October 7, 2005

Subject: **MINOR MODIFICATION for Individual Section 404 and 401 permits for TIP R-2616** for the proposed widening of US 601 from the South Carolina State Line to north of Marion Lee Road (SR 2105) south of Monroe in Union County; NCDOT Division 10. Federal Project No. STP-NHS-601(4), State Project No. 8.1690303, WBS Element 34485.1.1.

SITE 16 -L- STA. 315 + 56

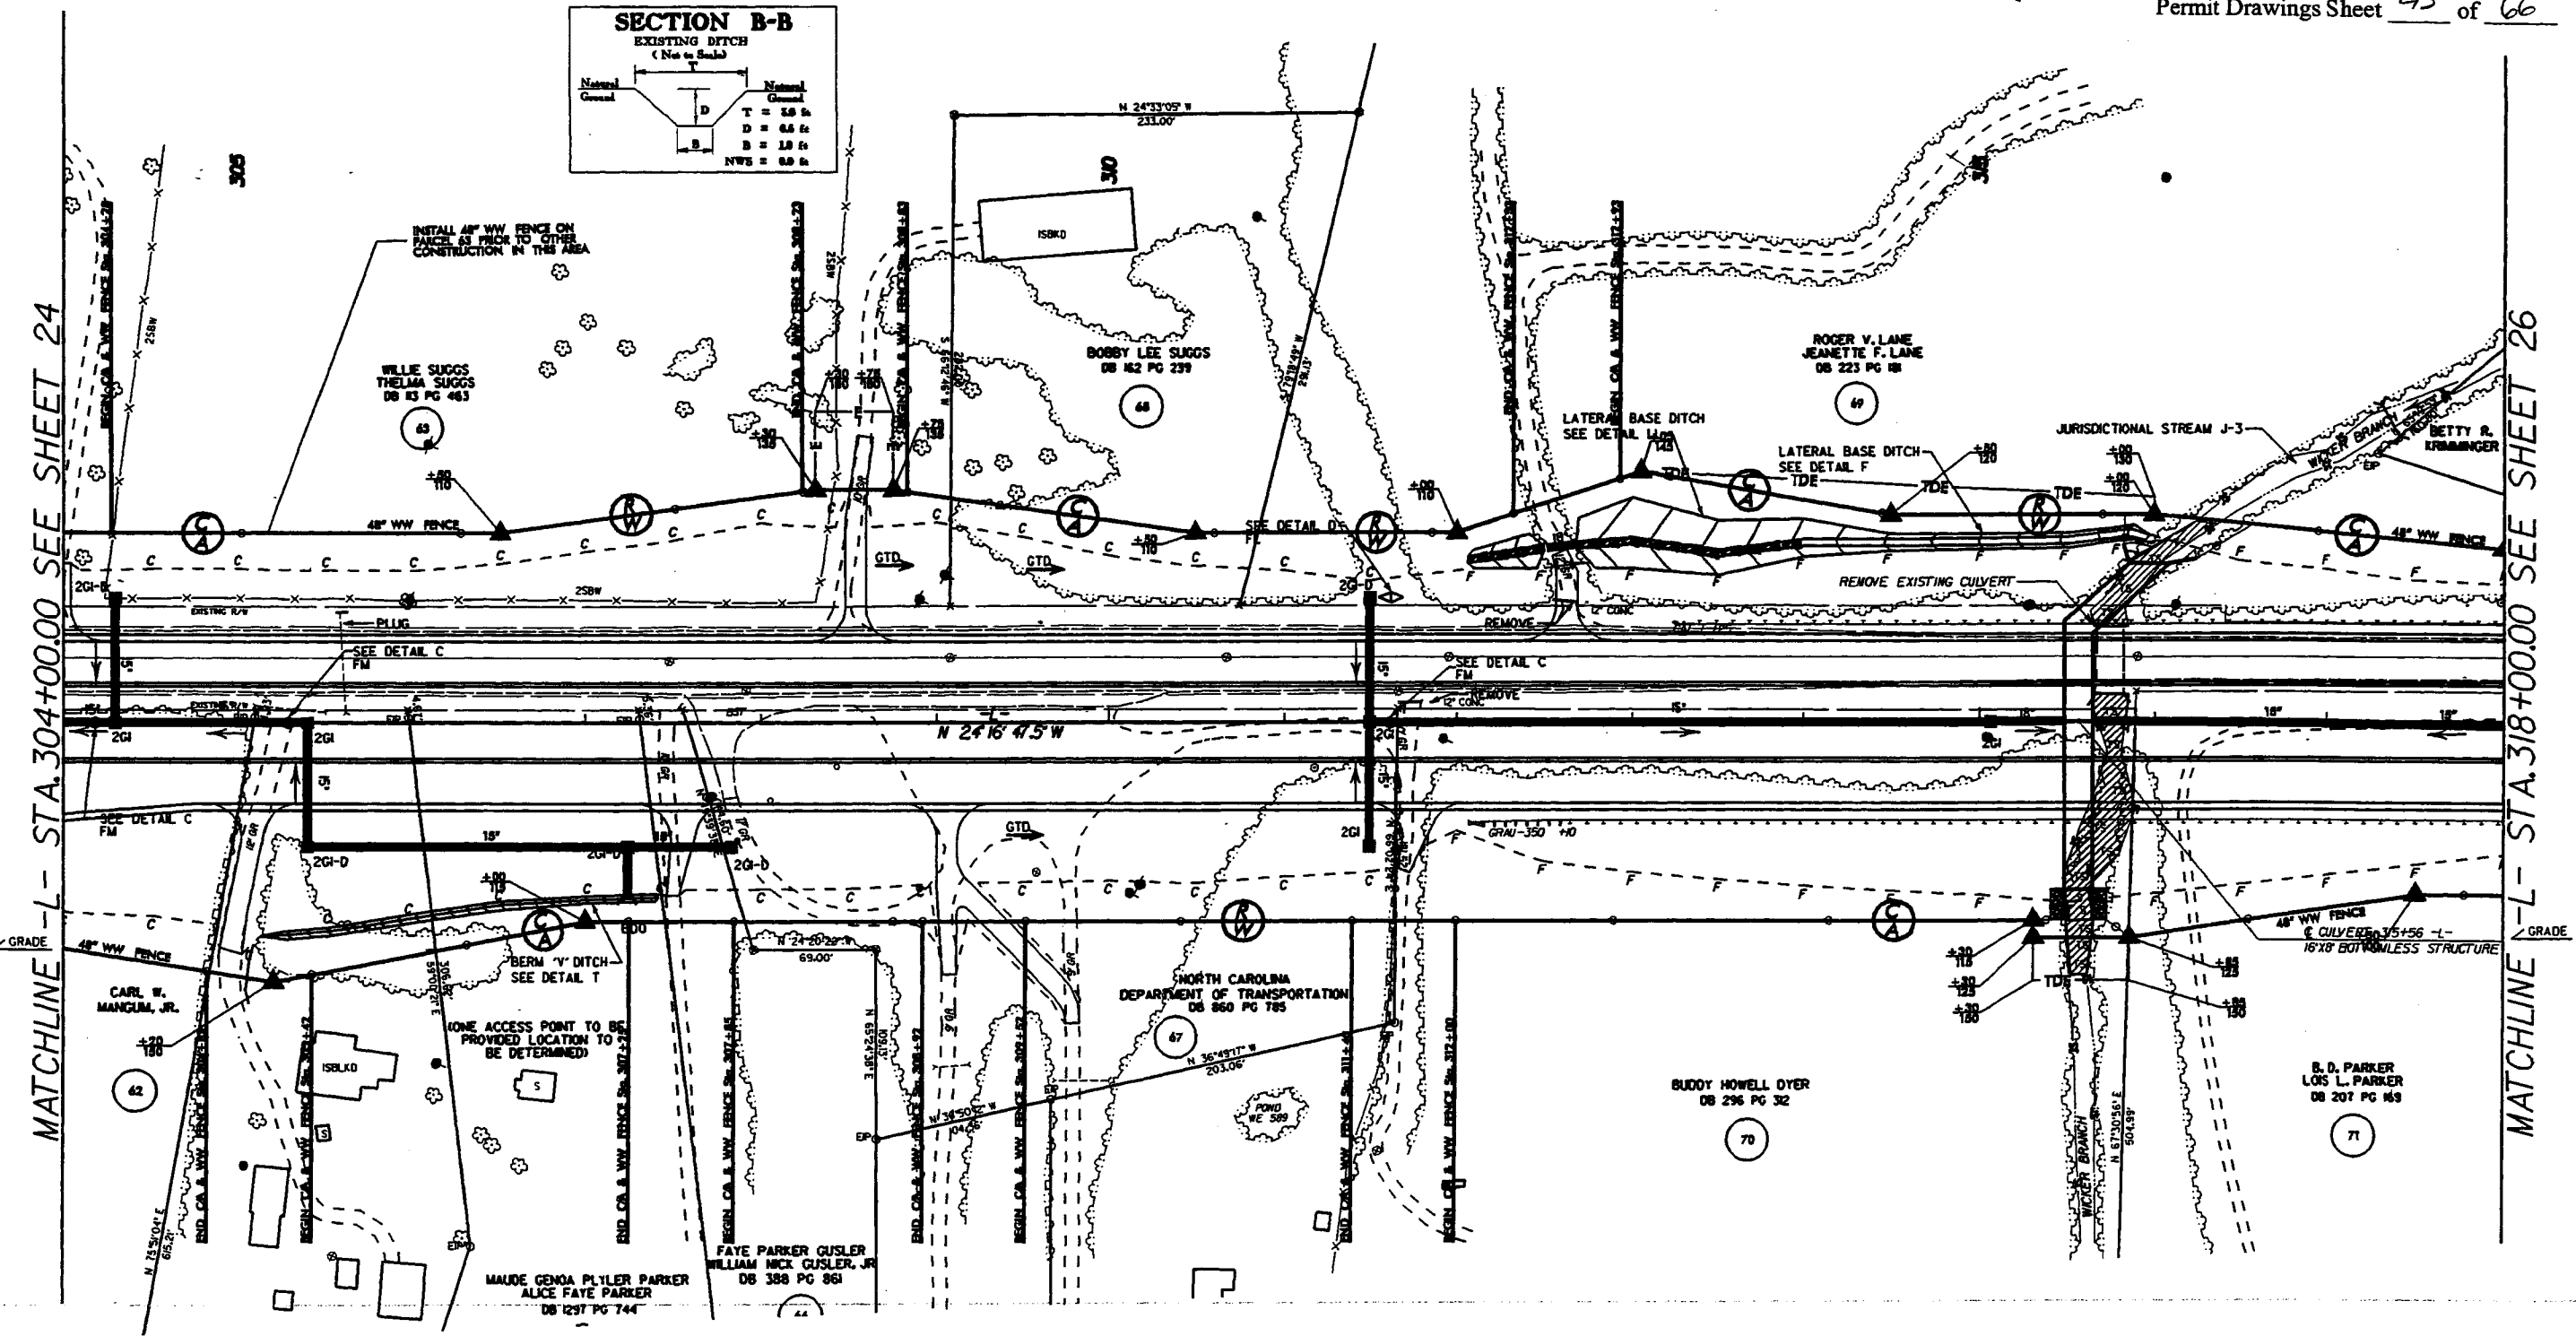
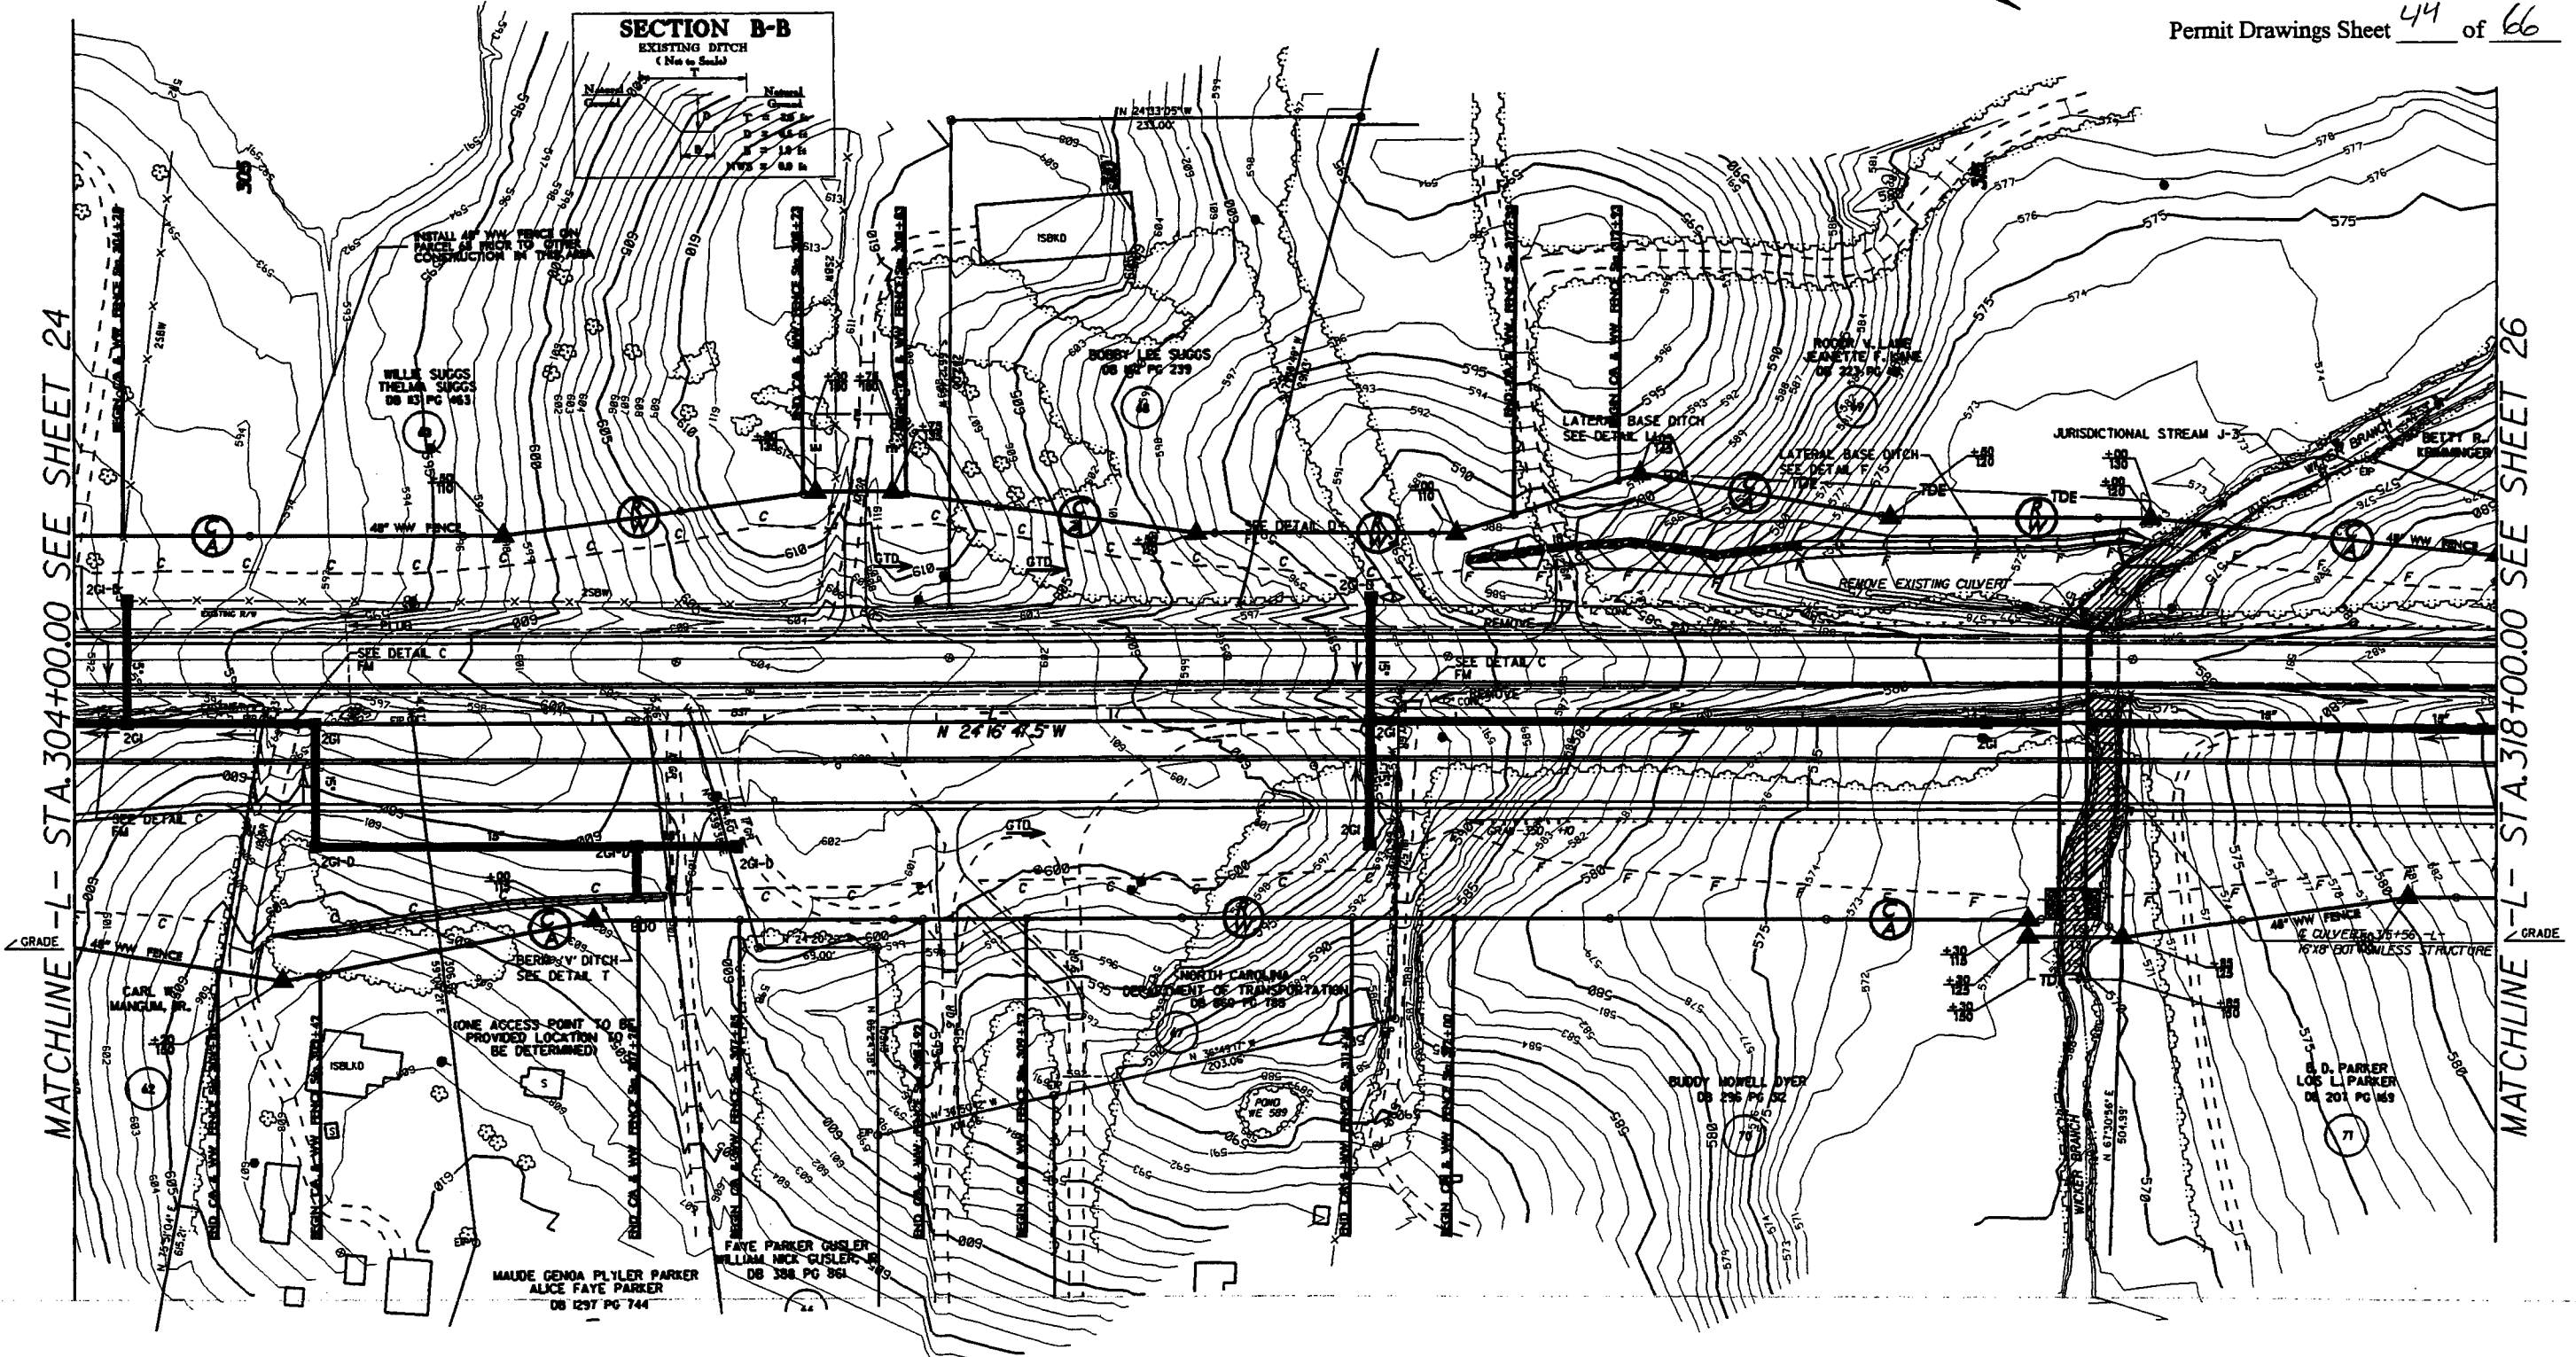
Please reference the July 21, 2005 Individual Permit application. During the Concurrence Point 2A and 3 meeting held on March 16, 2004, NCDOT made a commitment to investigate the feasibility of a bottomless culvert at the crossing of Wicker Branch, pending geotechnical studies and further design of the project. NCDOT has determined that it is feasible to replace the existing double barrel 8'x7' reinforced concrete box culvert with a single 16'x 8' bottomless structure. This revision will reduce the impacts at Site 16 from 210' to 25' of permanent stream impact. Permanent stream impacts are necessary due to the difference between the existing stream location and the new channel in the bottomless structure. The amount of temporary linear stream impact will increase from 20' to 210' to accommodate construction of the new structure.

These changes will reduce the total permanent linear stream impact for the project from 2,969 to 2,784, and increase the temporary stream impact from 464 to 654 feet.
